**From:**  
**Sent:** 17 January 2024 12:28  
**To:** DCAdmin  
**Subject:** Application number 2023/60/93539/E Ledgard Wharf

I would like to register my comments relating to the planning application for Ledgard Wharf, Mirfield

**Application number**  
2023/60/93539/E

Project	Proposed residential scheme at Ledgard Bridge, Mirfield
Client	Binks Executive Homes Ltd, Cawthorne, Barnsley S75 4EJ
Dwg Title	(17001)13_Landscape Hub
Scale	1:200, 100 @ A1
Date	Nov 23

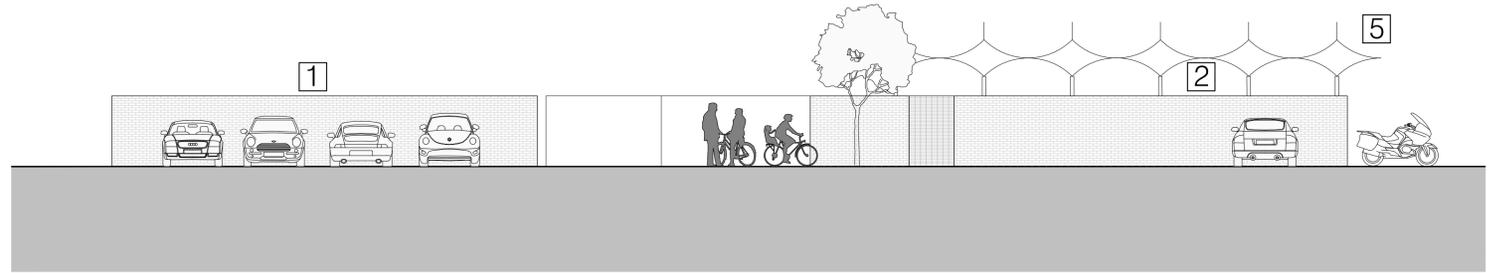
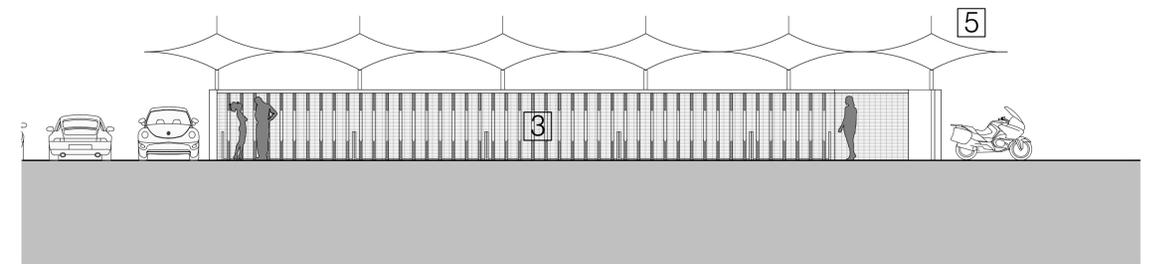
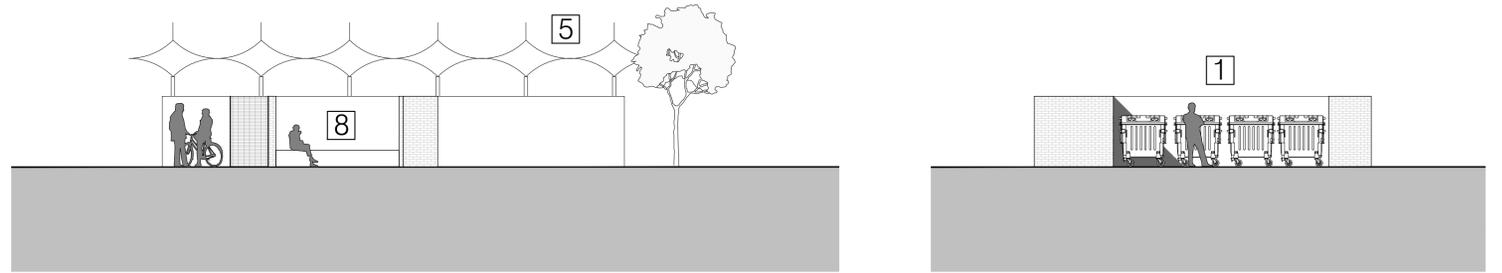
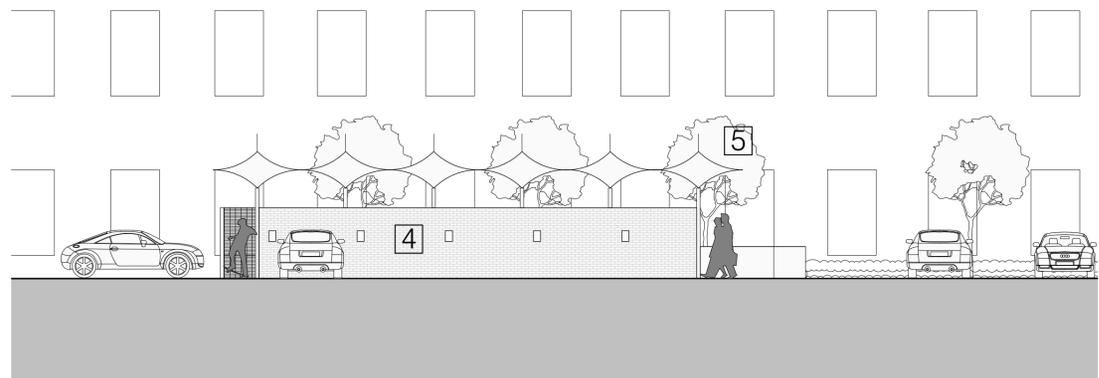
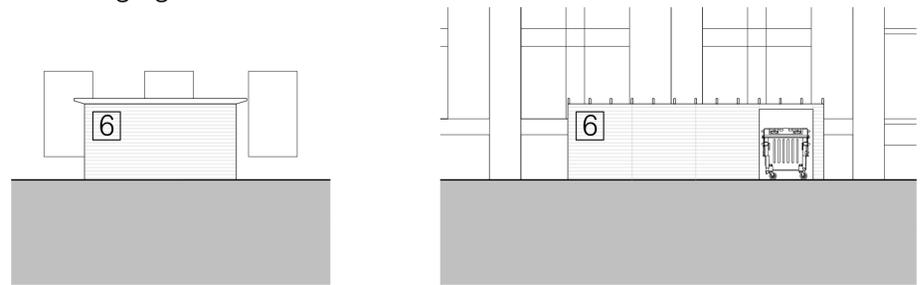
\*\* there is currently NO store to contain the current refuse bins located near the entrance to the existing site, and these bins are LESS THAN 6 metres away from the nearest building which is a residential home partitioned from the current refuse bins by a wooden fence.

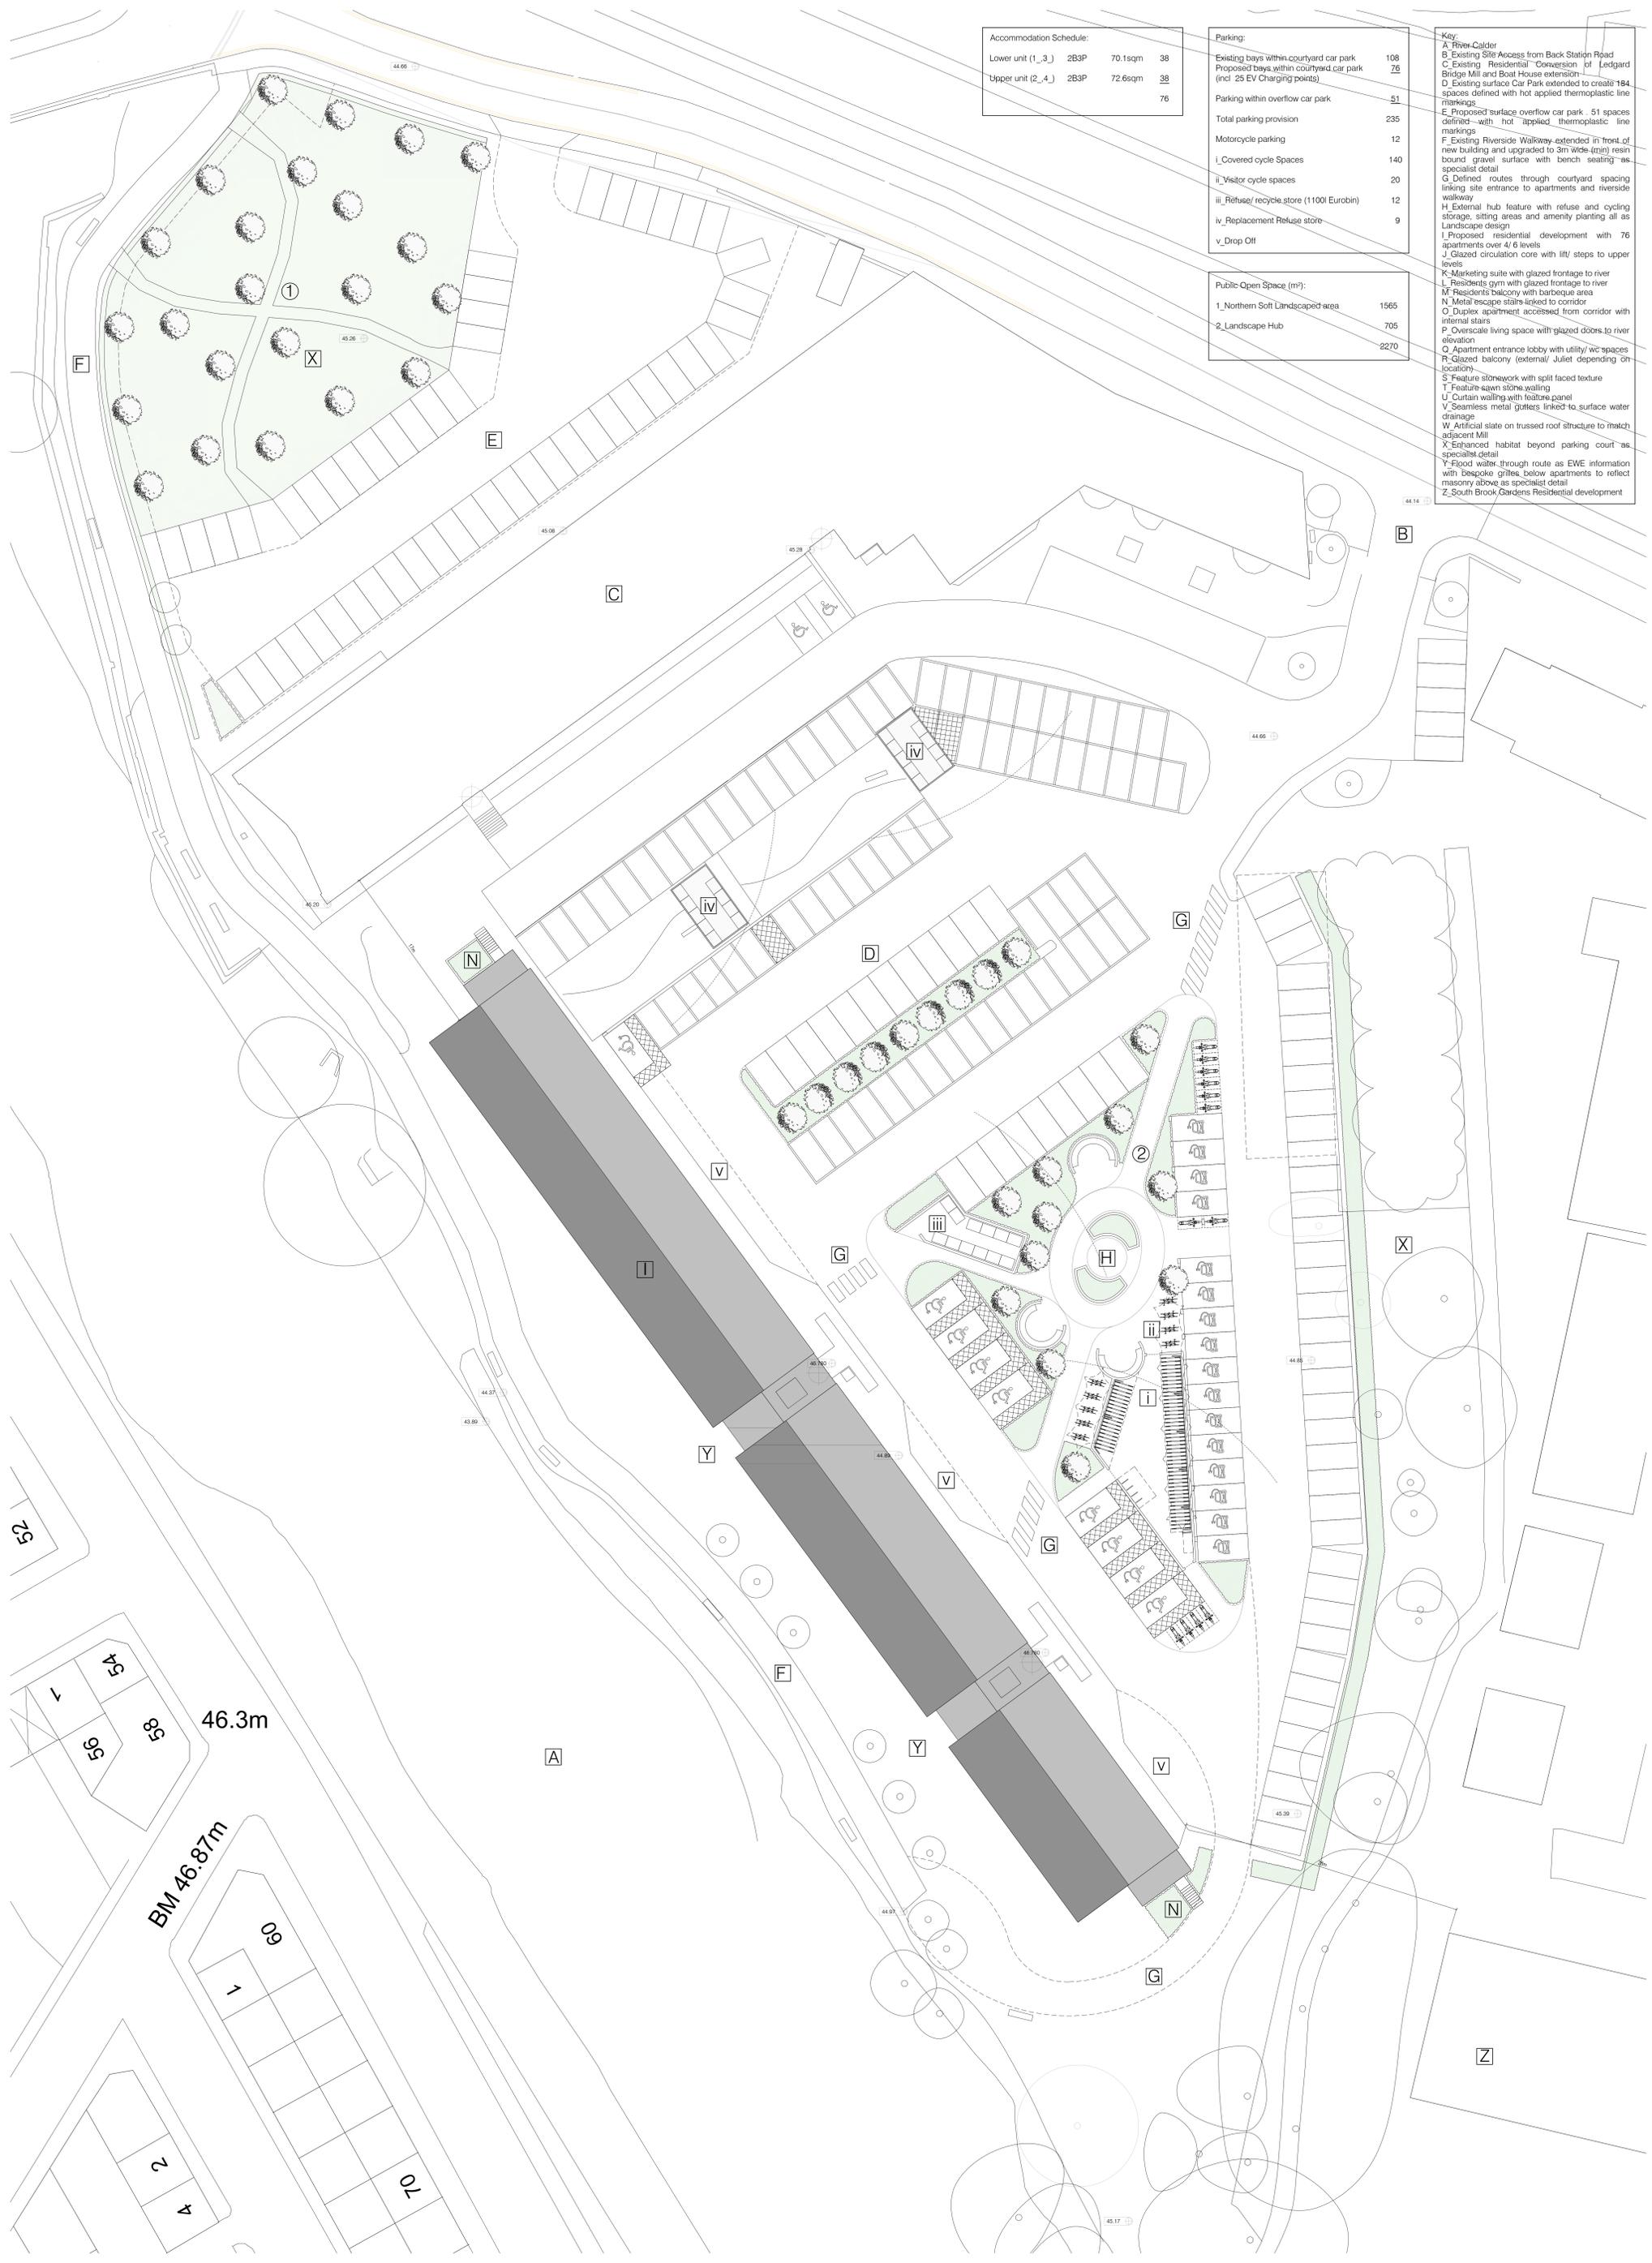
At the entrance to the current car park the proposed development appears to include 5 parking spaces in place of what is currently the location of the bins - is this parking arrangement acceptable, i.e. driving over the pavement to park?

In the new ('over spill') car park there is a row of parking spaces right next to the windows of the row of ground floor apartments - will this cause noise and air pollution issues? Perhaps it would be better to have some landscaping and have the row of parking spaces a little further away from people's homes?
